# TERRA ASSOCIATES, Inc.

March 28, 2023  
Project No. T-8264

Subject: Response to City of Mercer Island Comments  
Cheshire Short Plat  
7615 East Mercer Way  
Mercer Island, Washington

- References:
1. Geotechnical Report, Cheshire Short Plat, 7615 East Mercer Way, Mercer Island, Washington, Project No. T-8264, prepared by Terra Associates, Inc., dated May 12, 2020, 4th revision dated March 3, 2023
  2. Geotechnical Engineering Addendum, Cheshire Short Plat, 7615 East Mercer Way, Mercer Island, Washington, Project No. T-8264, prepared by Terra Associates, Inc., dated August 13, 2021
  3. Geotechnical Peer Review Comments, prepared by City of Mercer Island, dated January 5, 2023

APPENDIX B
RELATIVE SLOPE STABILITY RESULTS

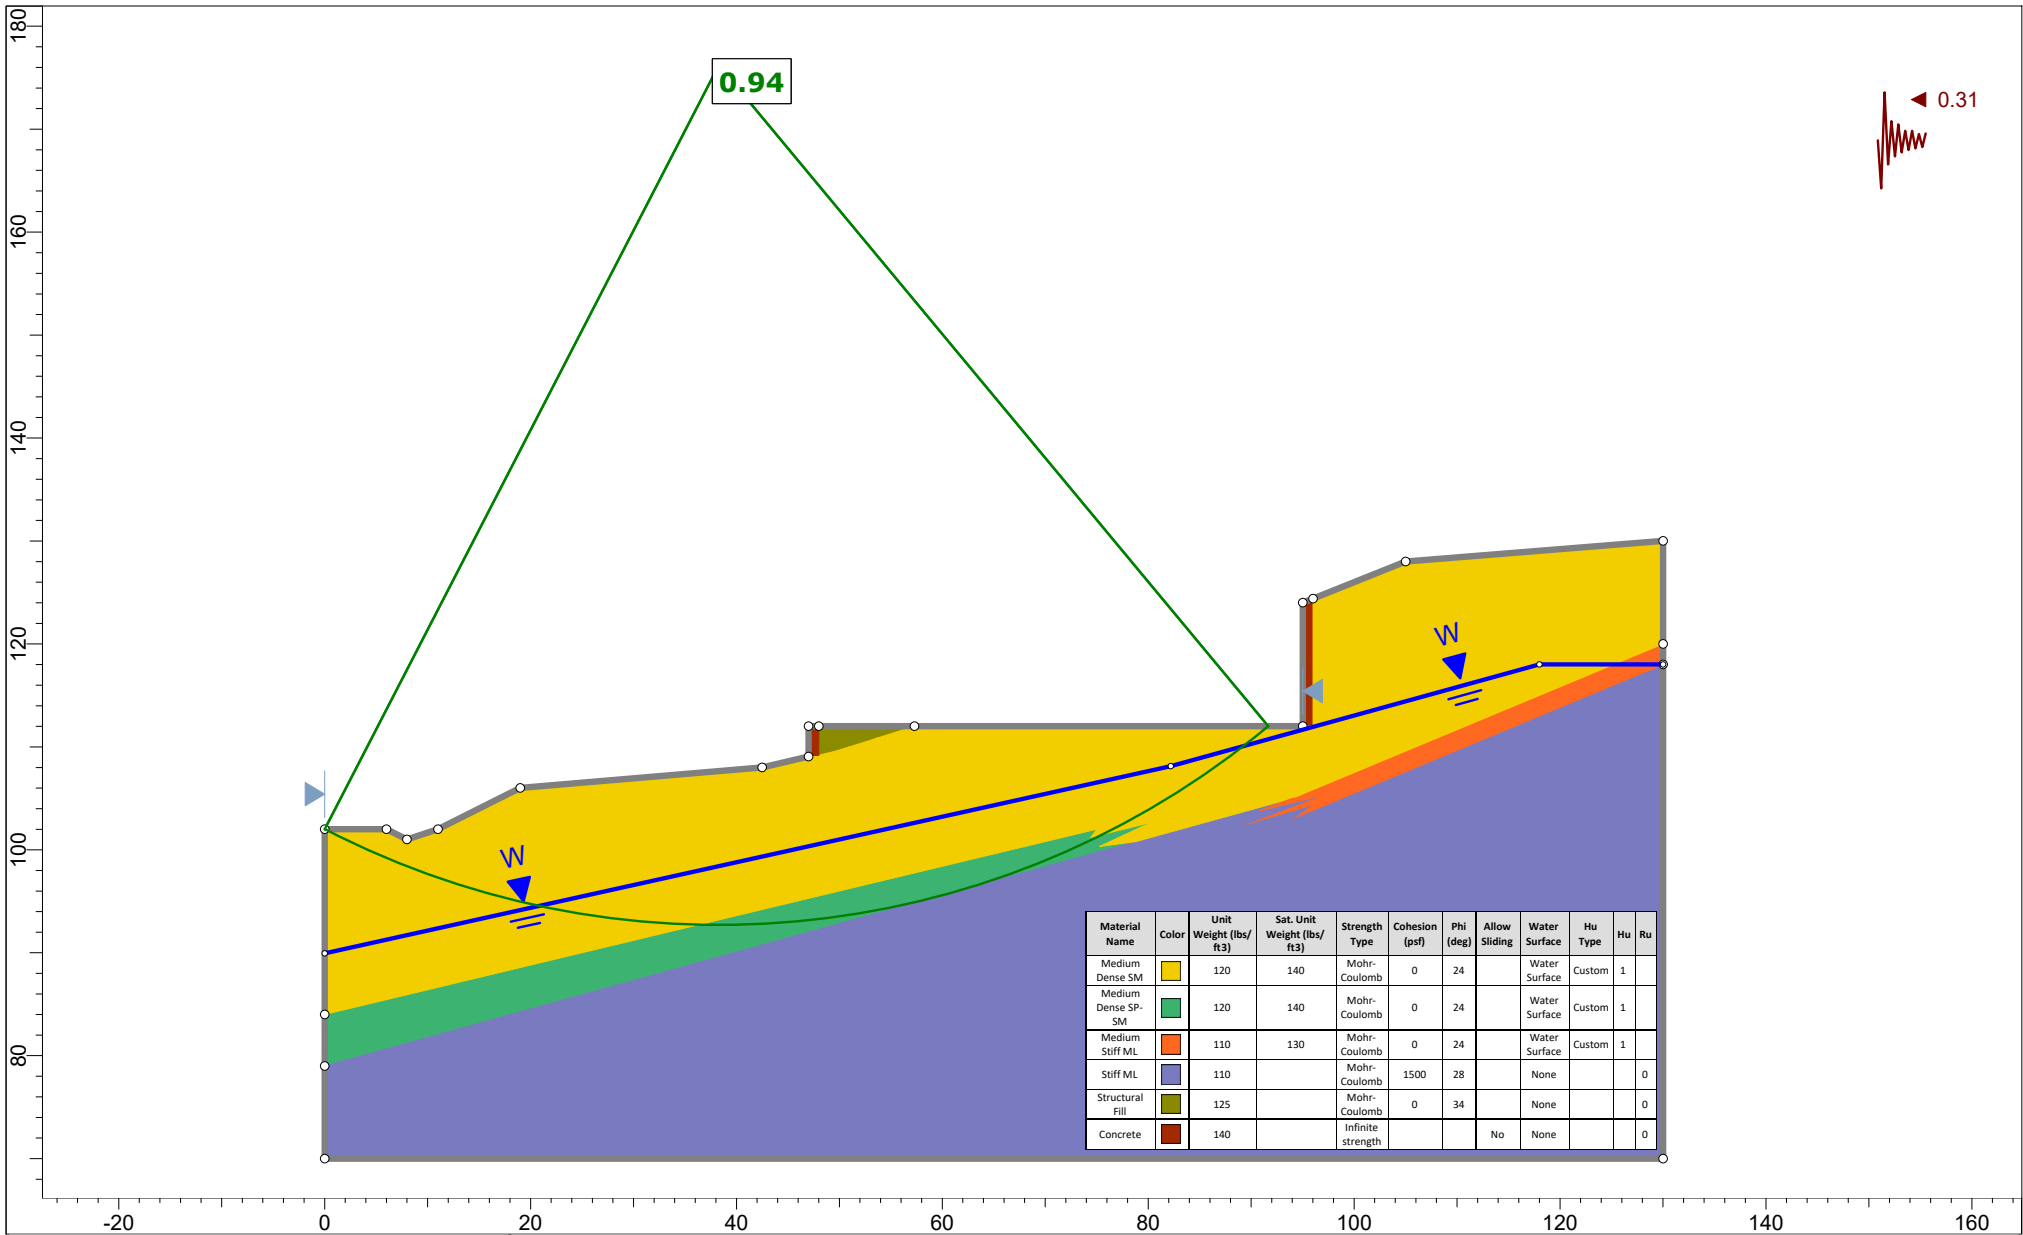
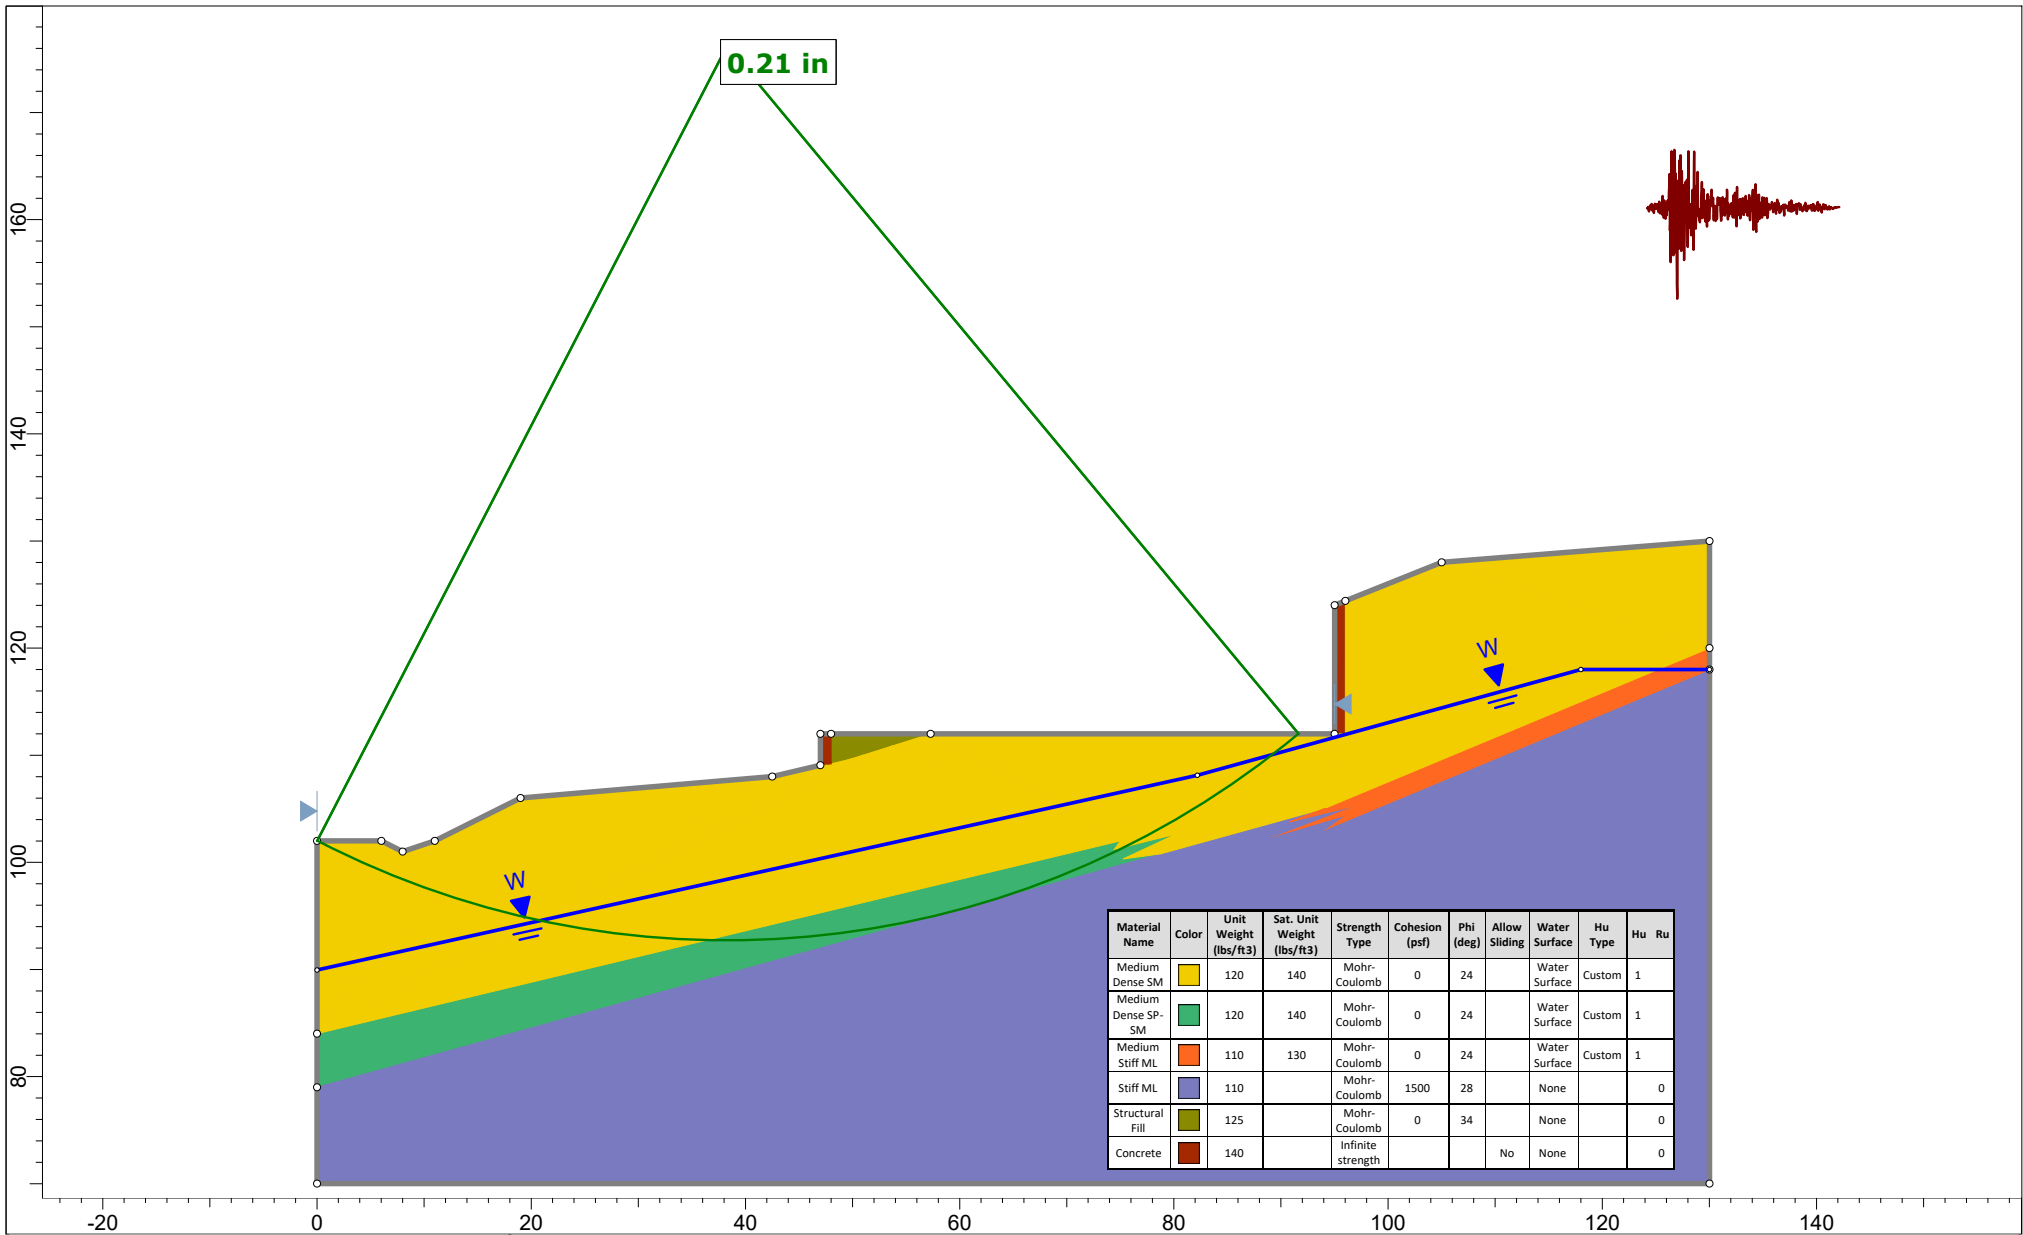
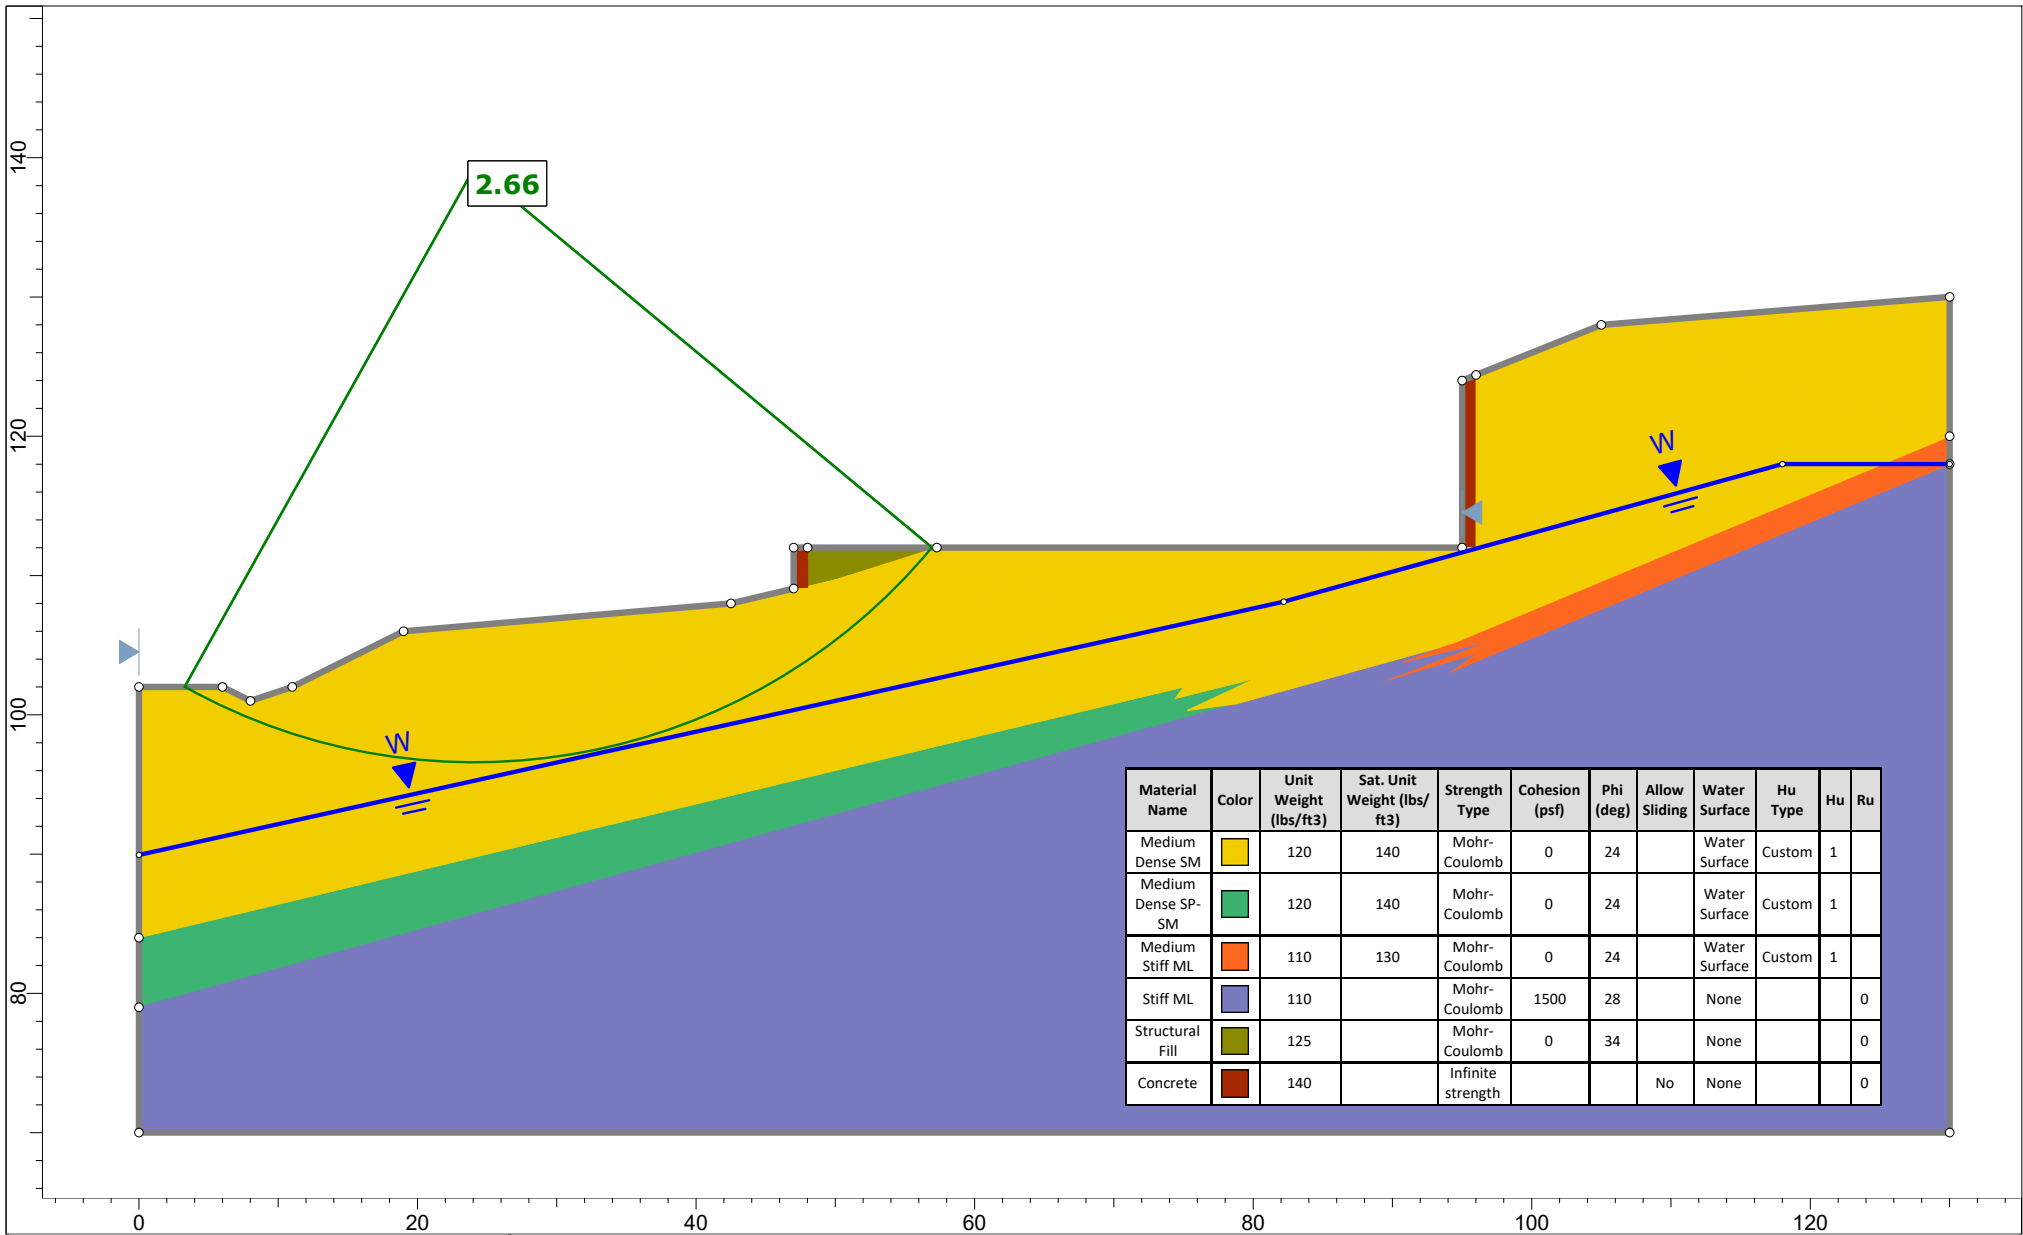
*In determining the residual strength from the residual strength ratio, the geotechnical engineer incorrectly used total overburden pressure, not effective overburden pressure in the calculations presented in Appendix C. Using effective overburden pressure will reduce the residual strengths of the layers below the groundwater.*

*Please revise residual strength calculations and associated stability and deformation analyses.*

*The geotechnical engineer also used averaging of subsurface conditions between borings B-1 and B-2. Please provide justification for this averaging. B-1 is off property while B-2 is on the property. B-1 indicates better soil conditions than B-2 and may unconservatively skew the residual strength calculations and in turn, the results of the stability and deformation analyses.*

The overburden pressures have been revised to reflect the effective overburden pressure.

The residual strengths have been revised and are included in the revised geotechnical report.

Averaging of soil parameters is a common way engineers use the limited subsurface information to assign soil properties to a layer of material. The subsurface exploration logs are used to prepare a soil profile that will connect common soil types between the various exploration locations. Once the soil types have been connected, the information from the subsurface explorations (density, moisture, texture, etc.) are used to determine the soil properties associated with the soil layer. By averaging between the two borings completed onsite, we are using the limited information to prepare reasonable soil properties that are in line with the overall soil profile and are not based on a single moment in the formation.

While the soil conditions in Test Boring B-2 indicate soils lower in strength, it is overly conservative to base an entire soil layer on a single boring if the soil types are consistent with other subsurface explorations. The upper approximately 14 feet of Test Boring B-2 and approximately 12 feet in Test Boring B-1 consist of silty SAND with gravel and therefore it is acceptable to use the information from both borings to prepare soil parameters for the single layer in the profile.

APPENDIX C
LIQUEFACTION RESULTS

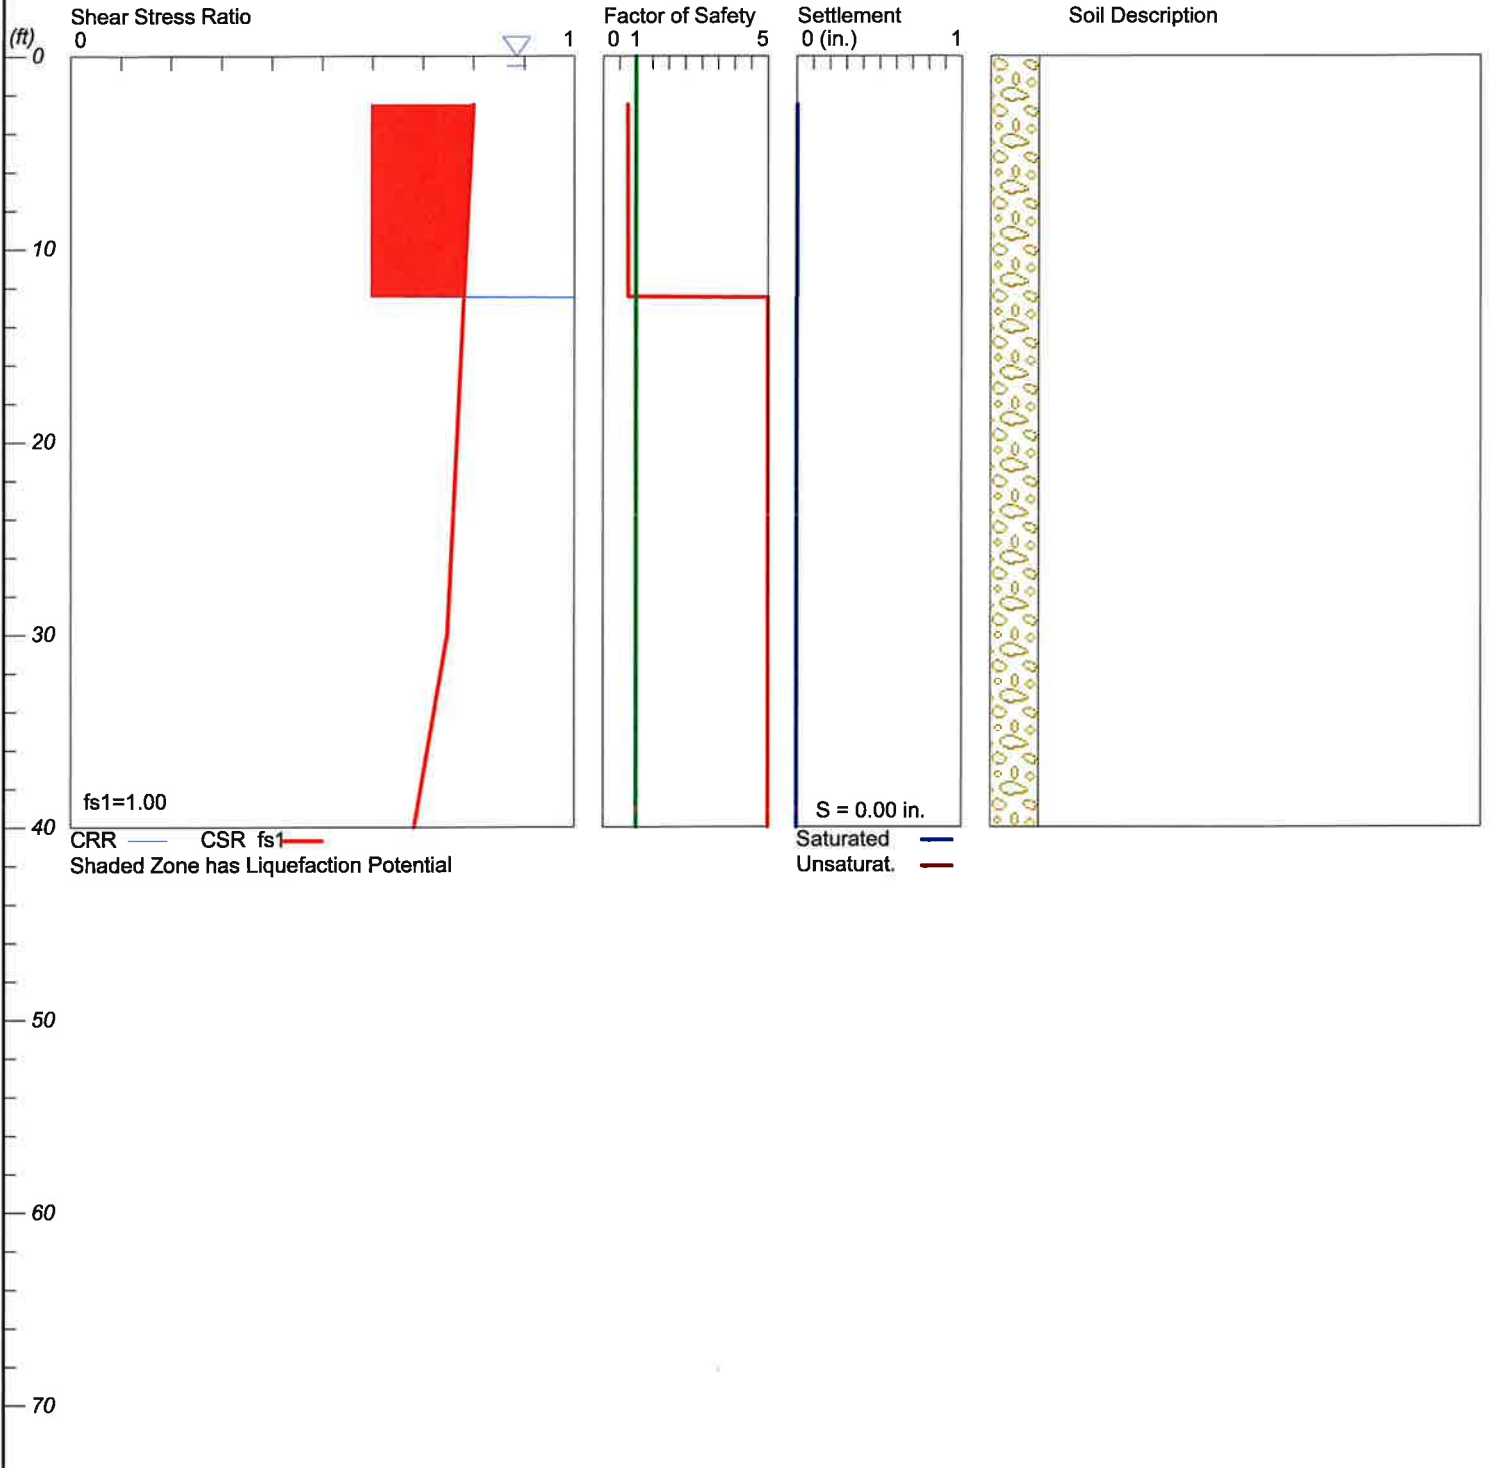
*Please verify whether the SPT values on the boring logs are normalized standardized SPT values i.e. (N1)60. The geotechnical report did not indicate as such. (See Section 4.4.2 of FHWA reference to determine normalized standardized SPT values from the raw field data). After determining the normalized standardized values, then the equivalent clean sand correction can be applied and Figure 4-19 in the Appendix C of the March 3, 2023 geotechnical report can be used to determine the residual strength ratio.*

The SPT values on the boring logs are normalized standardized SPT values.
